Cory Decarbonisation Project

Responses to Deadline 1 and Deadline 2 submissions on behalf of Landsul Limited and Munster Joinery (U.K.) Limited

Supplementary Expert Report by Dr Craig Edgar

Supplementary Report for Deadline 3

Alternative Site Layout

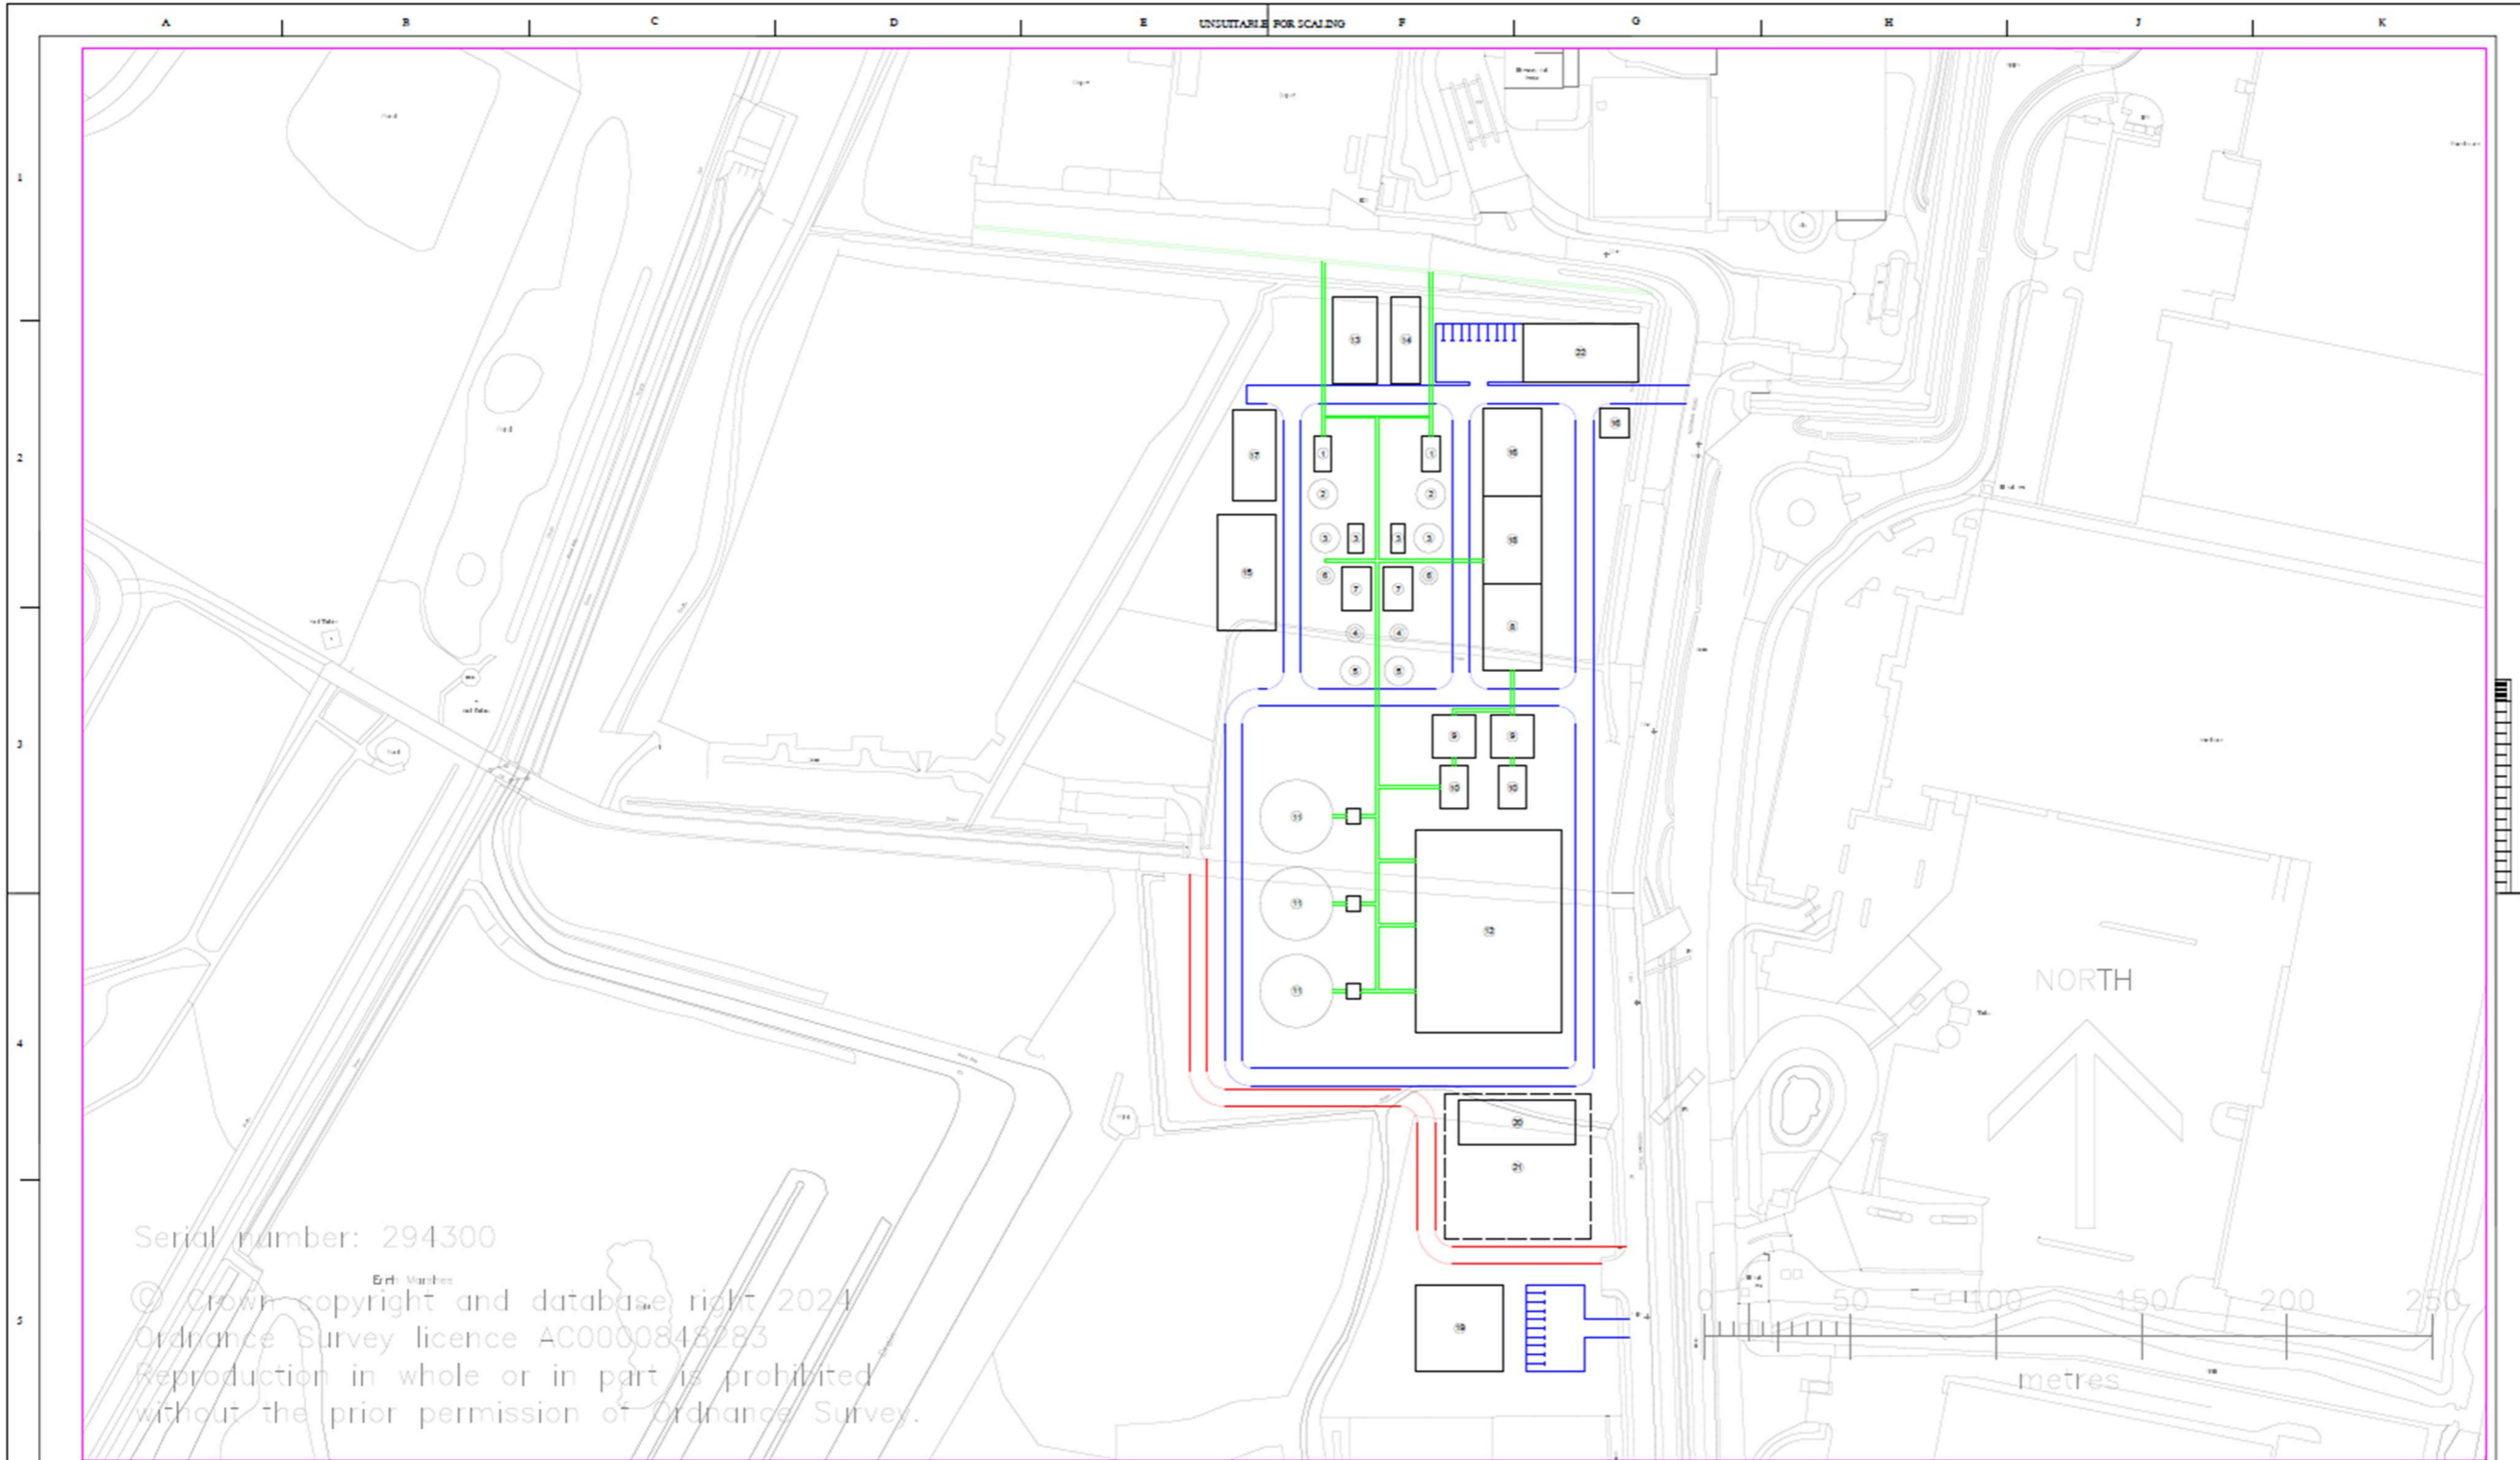
2.1 I have included an updated Alternative Layout in appendix A. The key differences to the previous layout (which I will discuss in more detail below) are:

- (a) The Heat Transfer Station (HTS) is now a fully segregated facility to match the Applicant's proposal.
- (b) The liquid CO₂ storage tanks have been relocated further away from Norman Road to address concerns raised by the Applicant in respect of their previous location in the Alternative Layout.
- (c) The water storage tank is now an underground tank to match the Applicant's proposal.
- (d) The Welfare Facilities and Control room have increased in size to match assumptions given by the Applicant.
- (e) The footprint for the cooling towers has been changed to match that of the Applicant.
- (f) The Water Treatment Plant footprint has been changed to match that of the Applicant.
